SN/SN/328740/2  
UKM/45023516.3

17 September 2012

**IPC REFERENCE NUMBER: TR030001**  
**APPLICATION FOR DEVELOPMENT CONSENT ("APPLICATION") BY**  
**ABLE HUMBER PORTS LIMITED ("ABLE") FOR THE PROPOSED**  
**MARINE ENERGY PARK ("AMEP")**  
**OUR CLIENT: C.GEN KILLINGHOLME LIMITED ("C.GEN")**  
**(REFERENCE 10015531)**

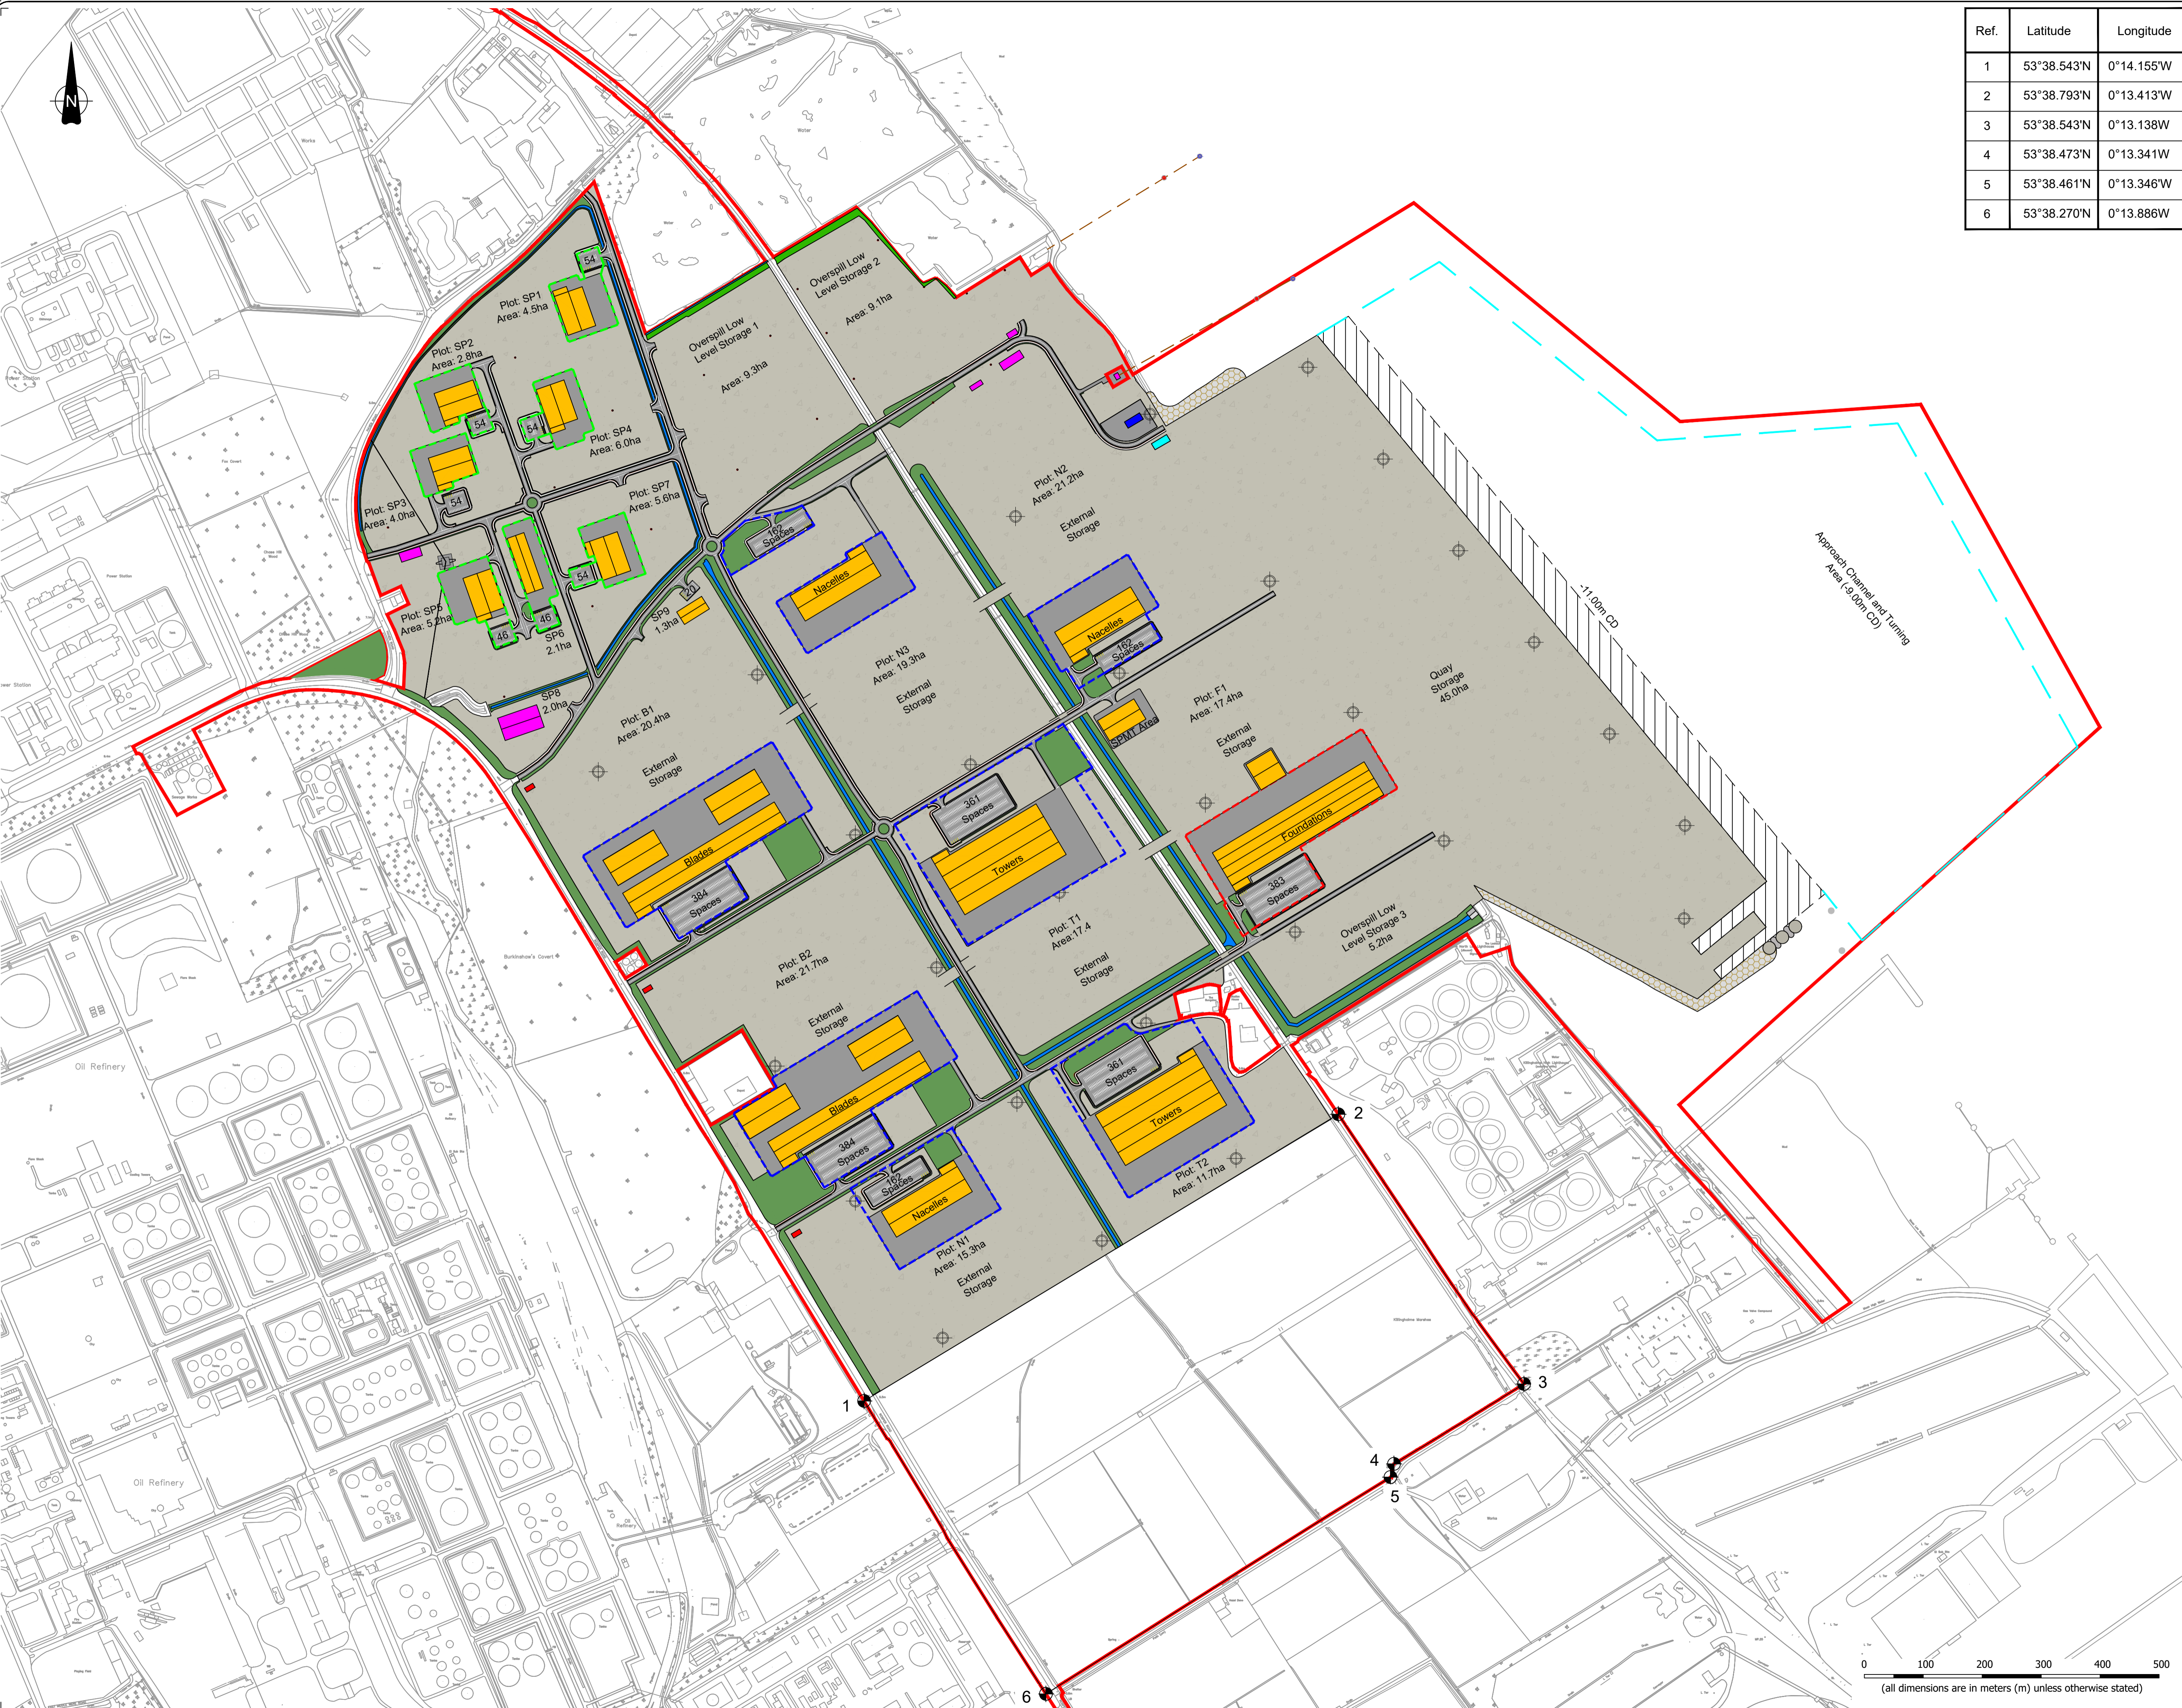
- 4.2 A number of revisions to the Application have been proposed since the Application was made. These comprise new drawings (for example a new Works Plan for the proposed railway loop within AMEP), although additional planning/other drawings have not been updated e.g. the Indicative Masterplan. A comprehensive set of revised drawings, with an indication of which drawings have been replaced, is important. In connection with this, C.GEN would welcome confirmation from Able that the environmental impact assessment contained in the ES is not affected by the details that have changed since the date of the Application;
